Application Ref:	2026/0496			 Ribble Valley Borough Council www.ribblevalley.gov.uk
Date Inspected:	04/09/2026	Site Notice:	NA	
Officer:	EP			
DELEGATED ITEM FILE REPORT:				APPROVAL

Development Description:	Proposed rear dormer and erection of a garden room.
Site Address/Location:	Casa Mia 8 Beauley Avenue Simonstone BB12 7HU

Ground Floor Plan as Proposed

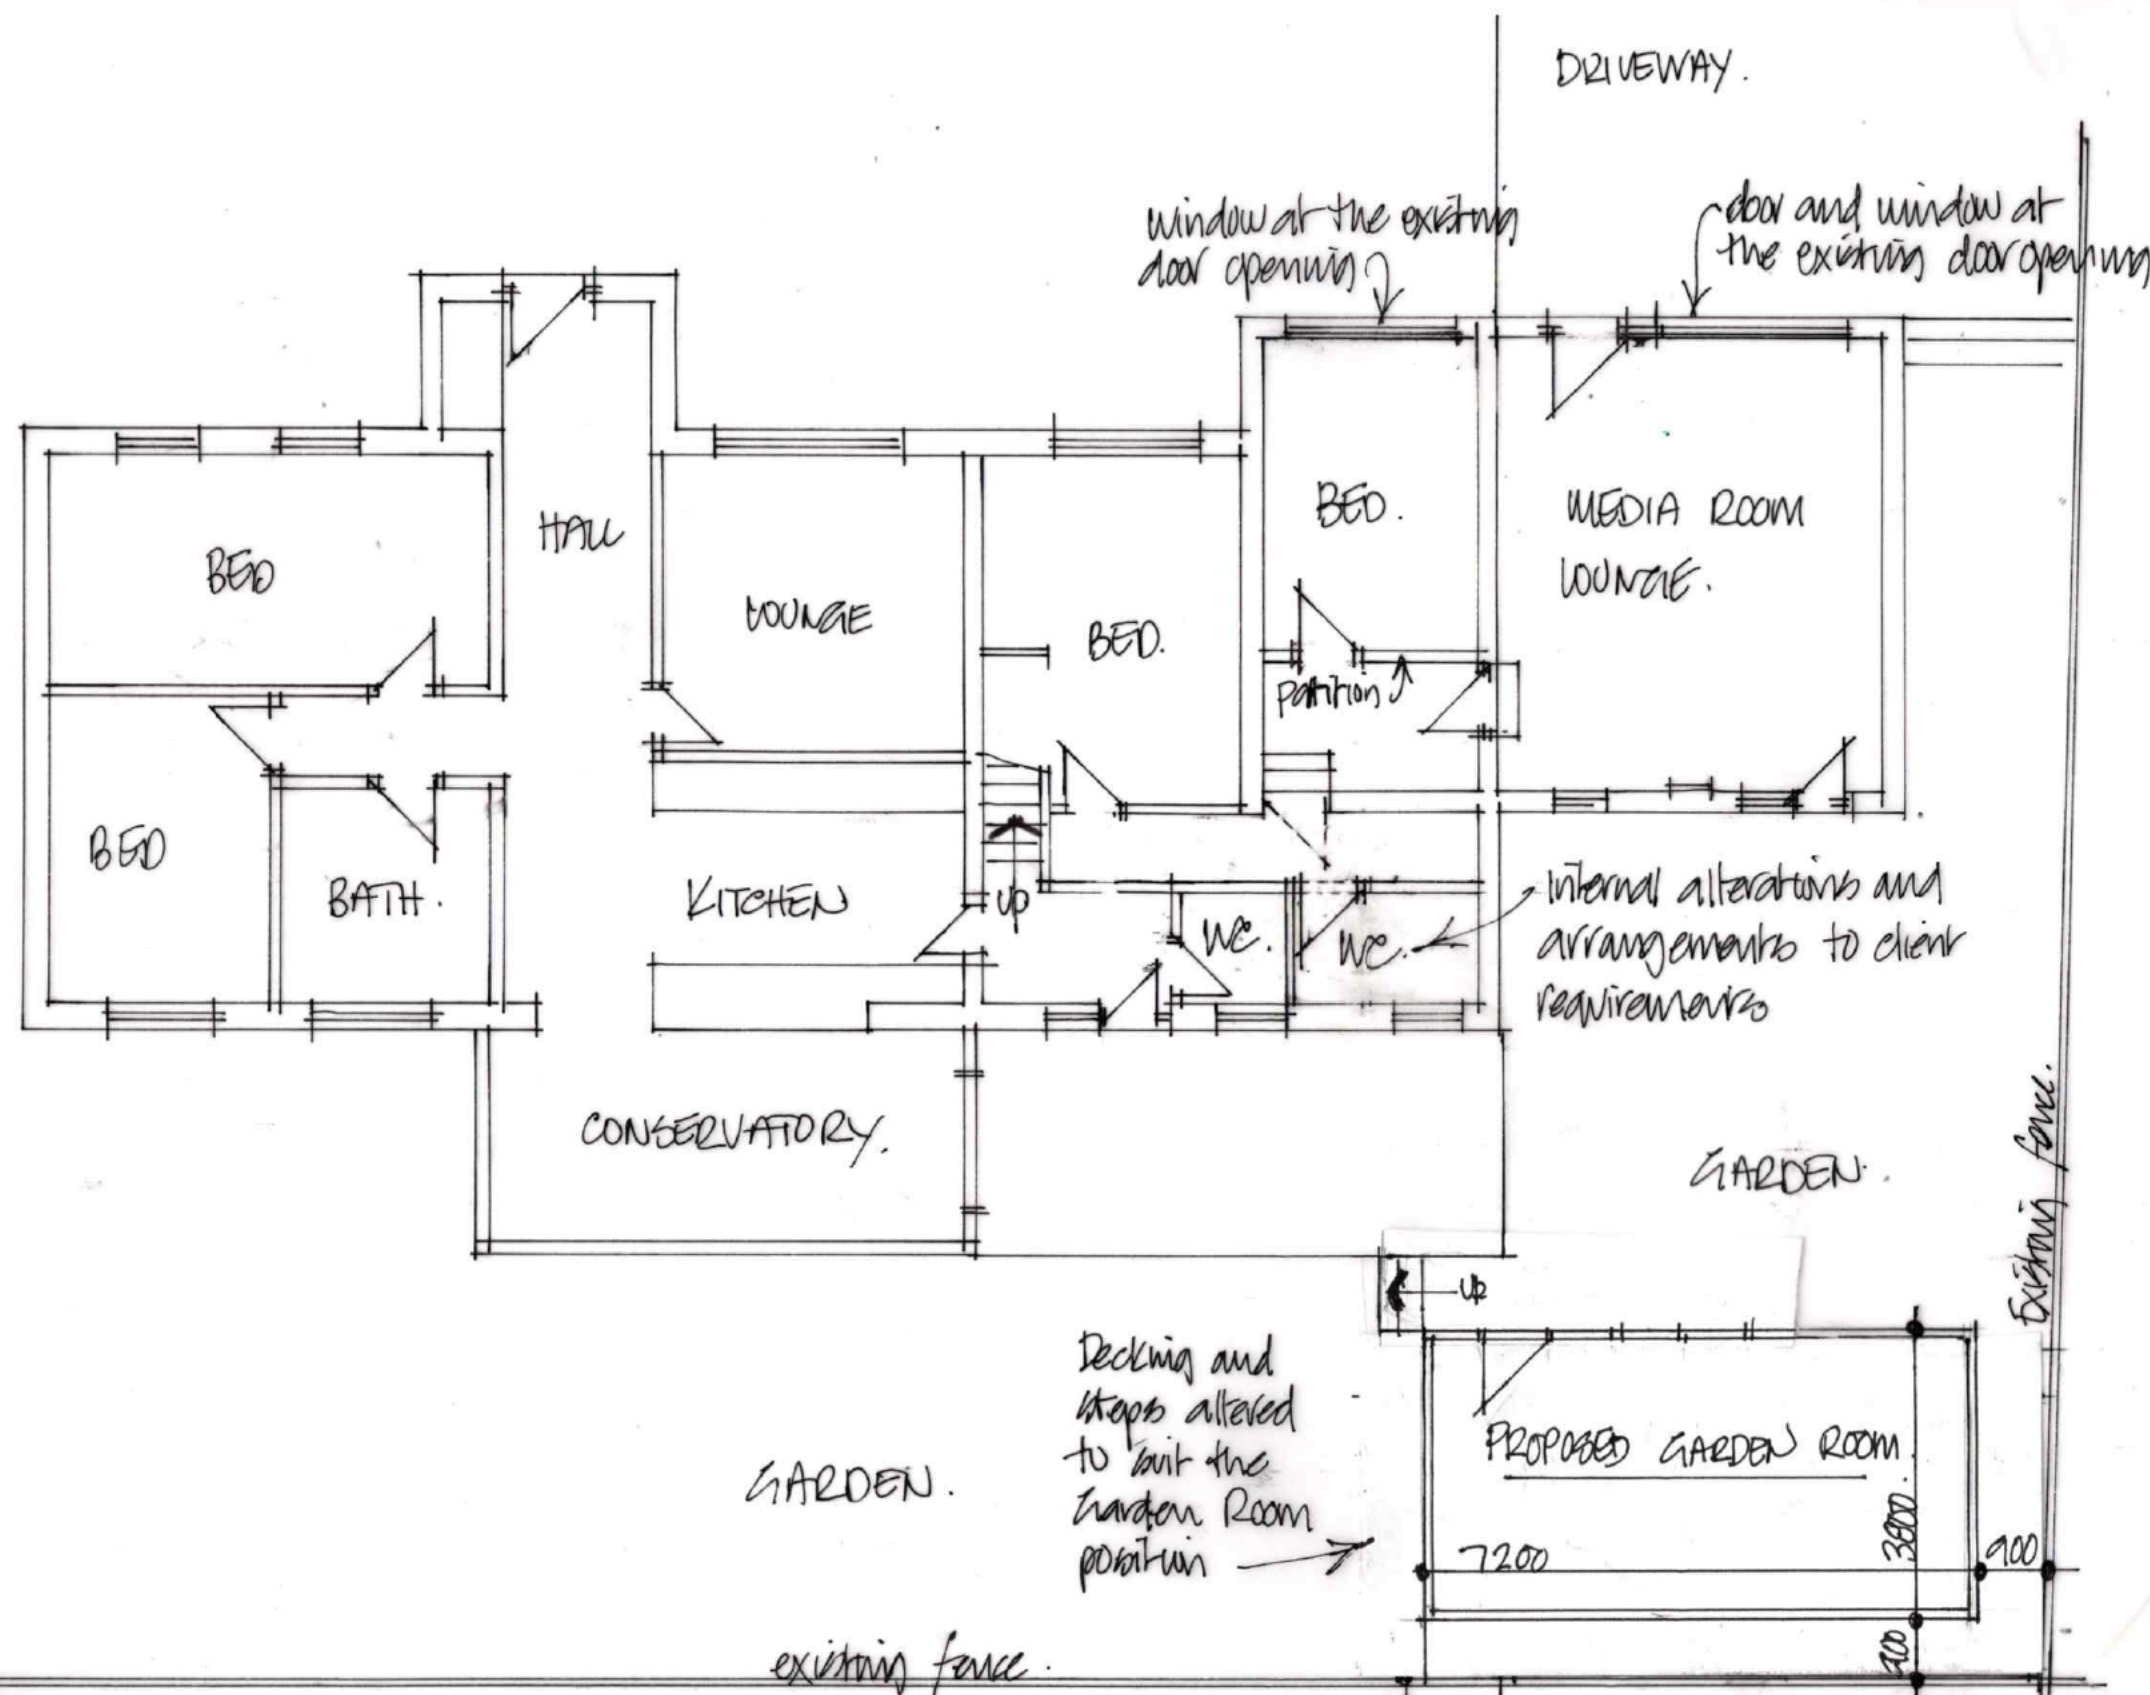
The existing garage doors will be replaced with standard window openings to accommodate conversion to living space. Whilst this is readily visible, it is not considered it would appear out of character. It is a modest alteration that does not substantially alter the appearance of the dwelling.

The proposal involves the conversion and therefore loss of the existing garage space as parking. However, the property benefits from a substantial driveway with plenty of off-road parking to mitigate this loss.

REAR ELEVATION - WEST.

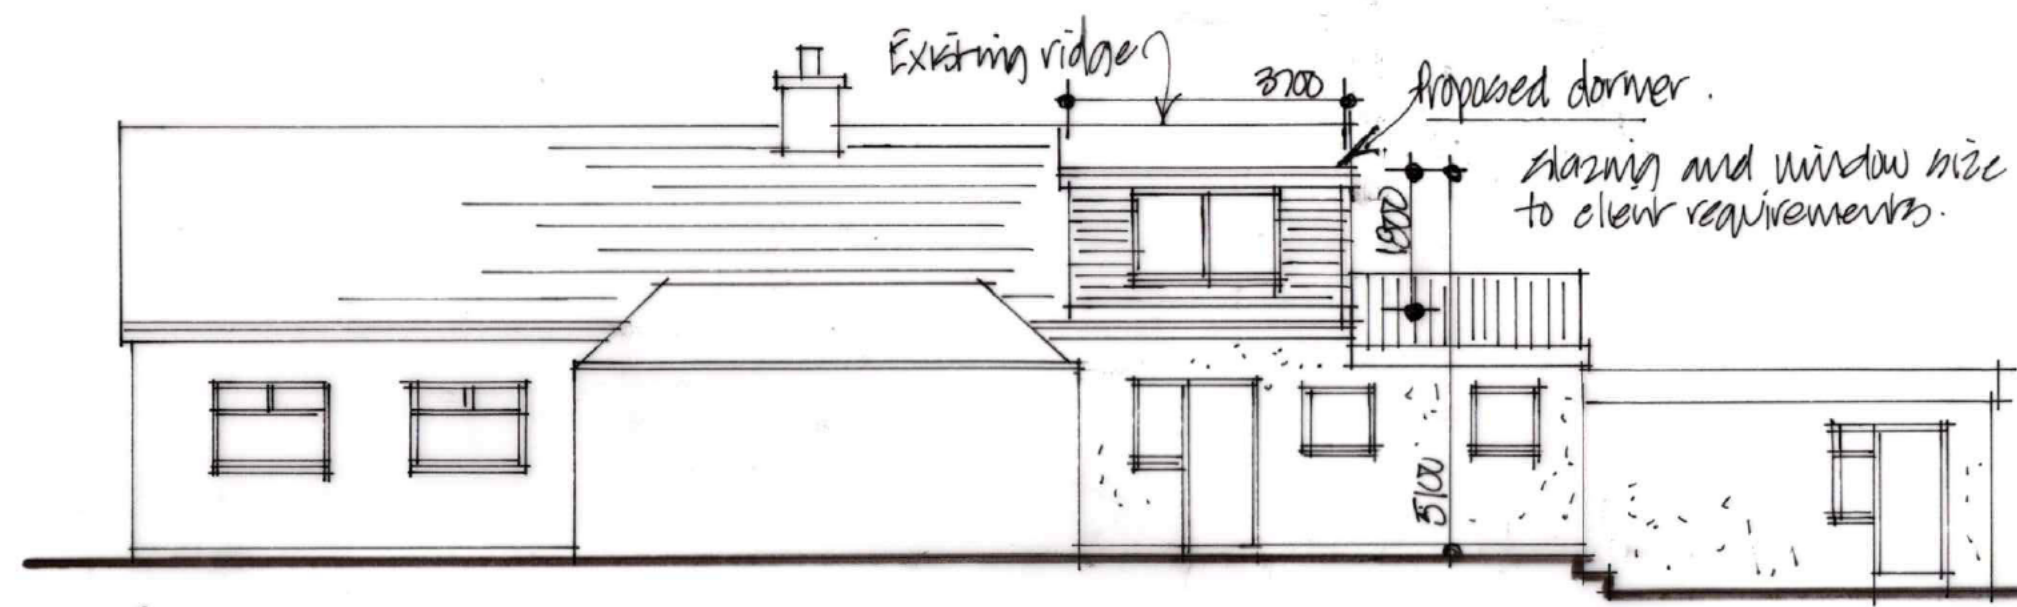
The proposed dormer extension features window openings in the rear elevation, however, there is a substantial distance between this opening and neighbouring receptors to the rear to mitigate any direct overlooking. There is also established, tall boundary treatment at the rear of the site that provides screening.

Proposed Garden Room

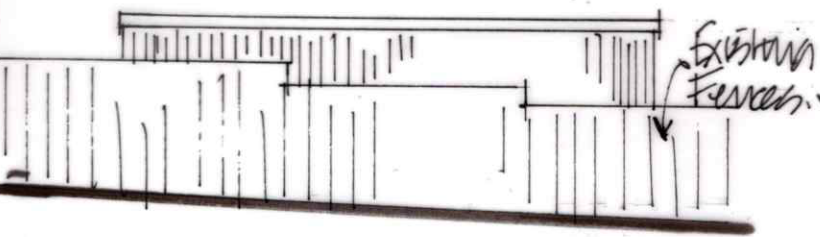
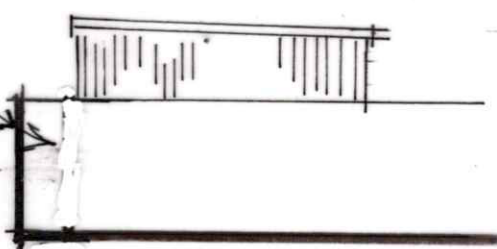
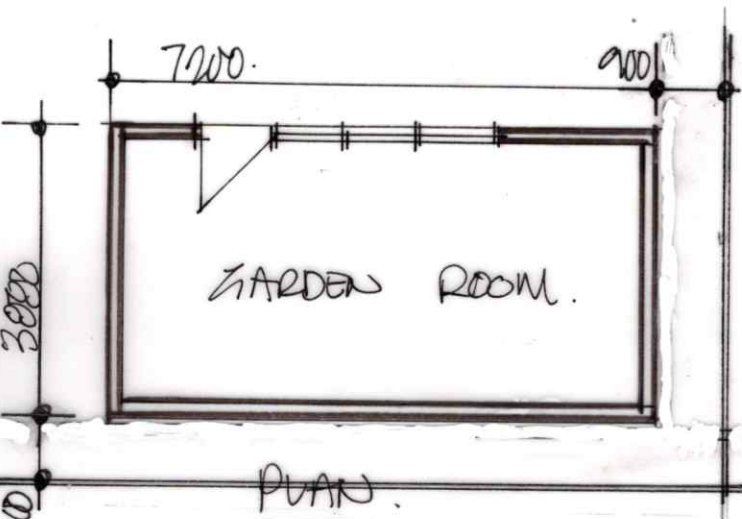
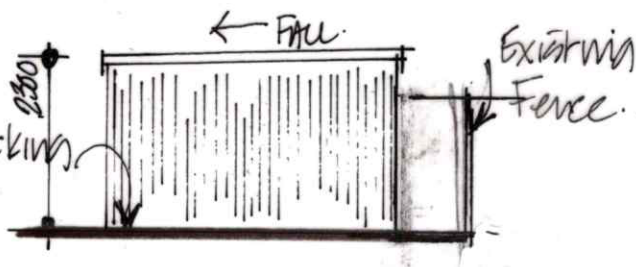
The proposed garden building is located in the southwestern corner of the garden, in close proximity to the shared boundary. The application dwelling is on a higher ground level than the adjoining neighbours and as a result the garden room would have a comparable impact in respect to overbearing or loss of light as the existing fence panels. The neighbouring property to the south benefits from a similar detached structure which will provide a level of screening of the proposal. The garden room is only marginally taller than the boundary fence currently in situ.

The proposed garden room is located within the rear garden and as such is completely screened from within the public realm. The building itself has a modest footprint and would be a subservient addition to the residential curtilage. The garden room will be constructed in timber effect cladding which is typical for a residential building of this nature.

Existing and Proposed Roof Plans

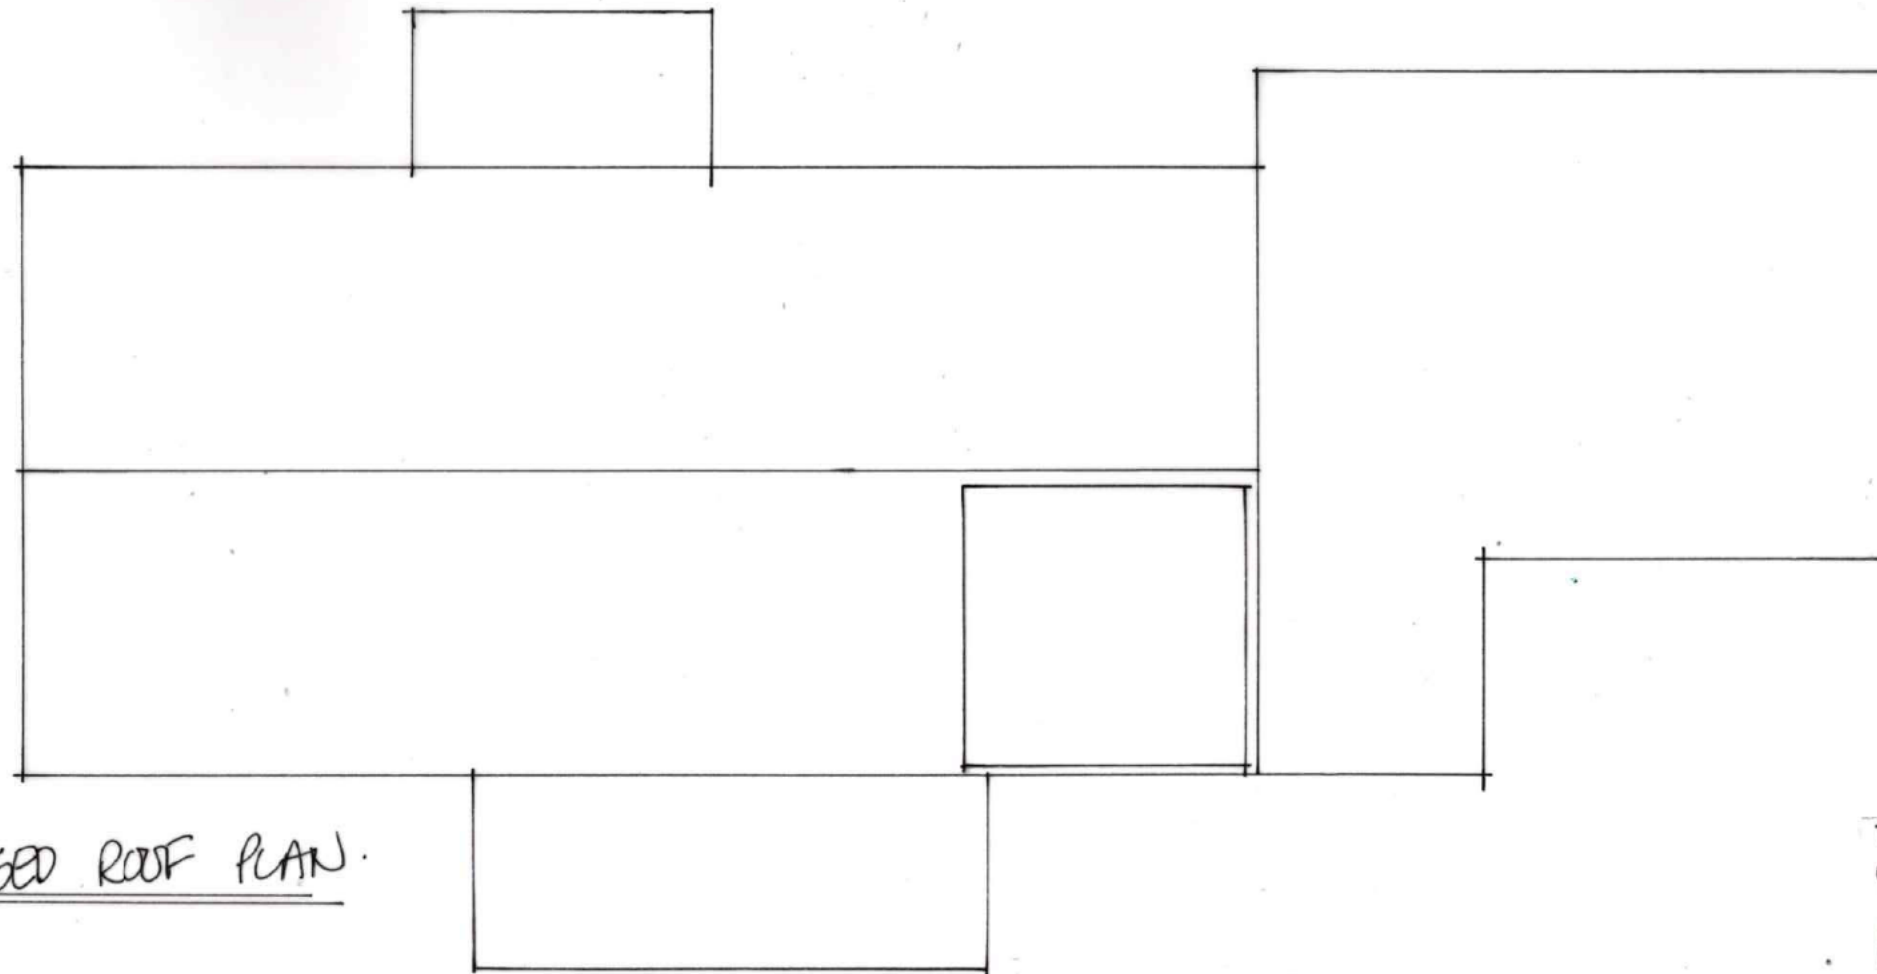
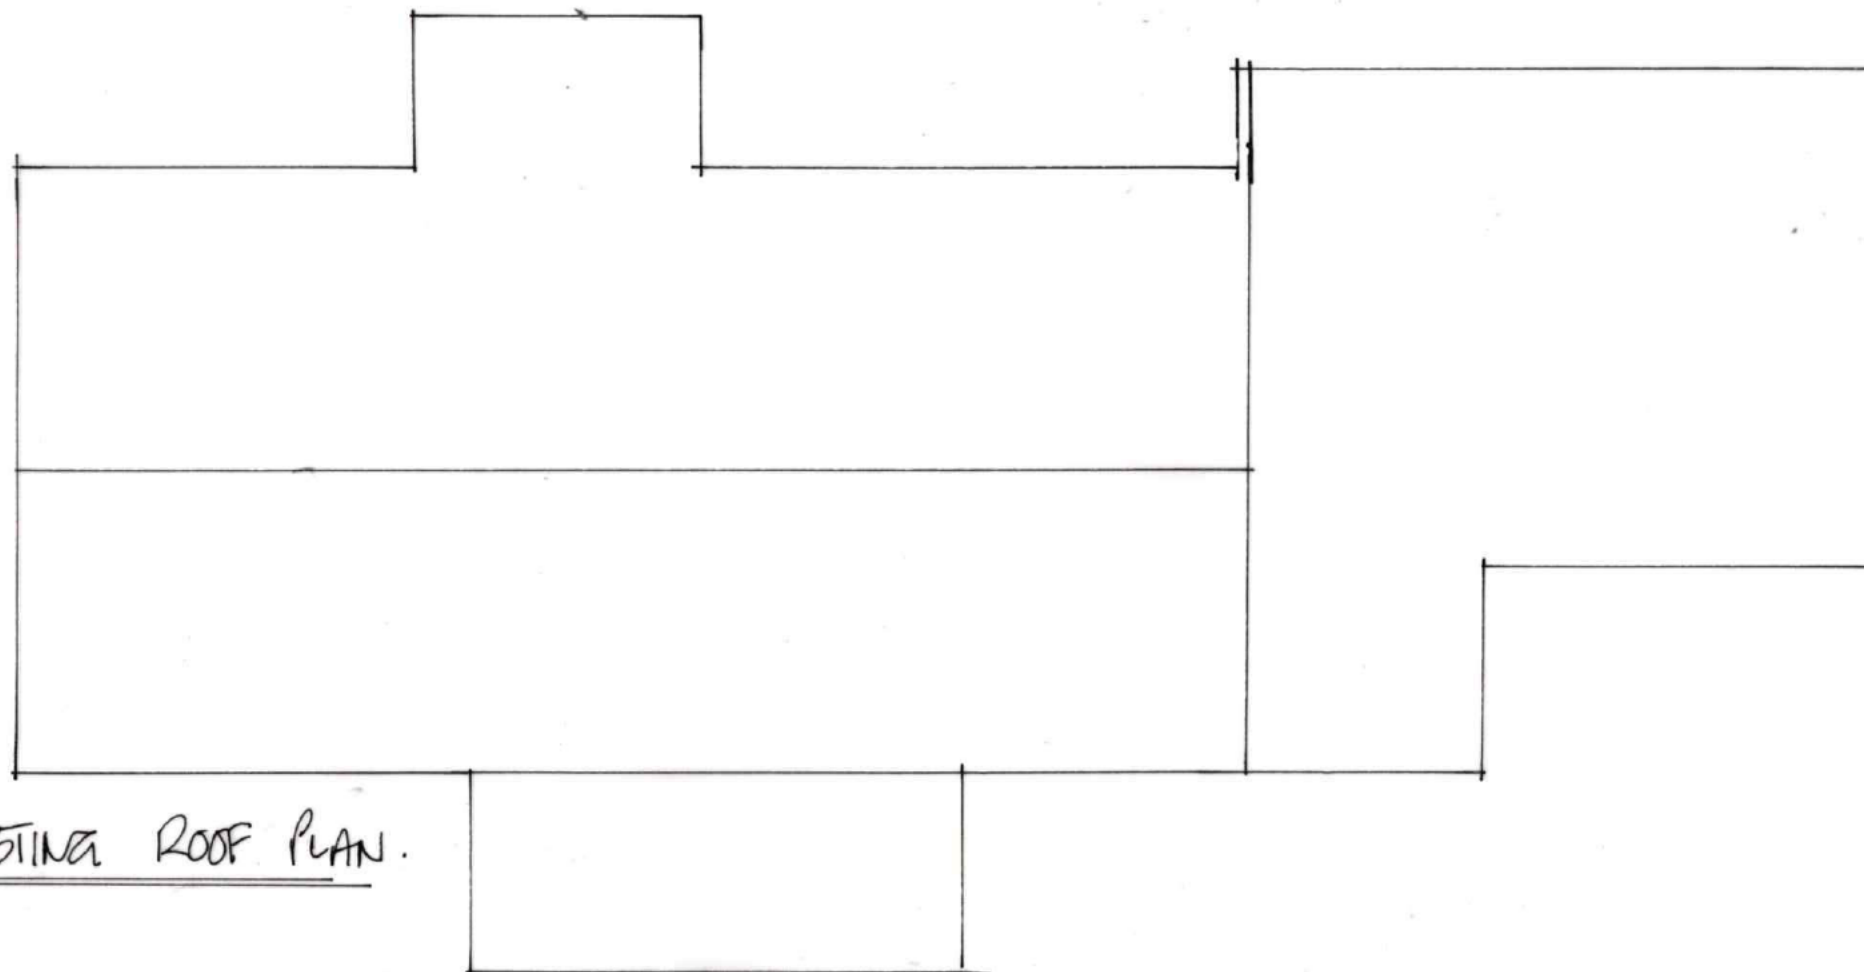
The proposed dormer extension will be located within the rear roof slope and as such does not host a readily visible position from within the public realm. Nonetheless, the dormer occupies a small portion of the roof slope and is set above the eaves and below the ridge of the main dwelling. As such, the dormer would not read as a prominent or dominant addition to the roof slope. The dormer will be faced in black pvc cladding which has a similar appearance in terms of colouring to the roof tiles. Given the screened location, this choice of materials is acceptable.
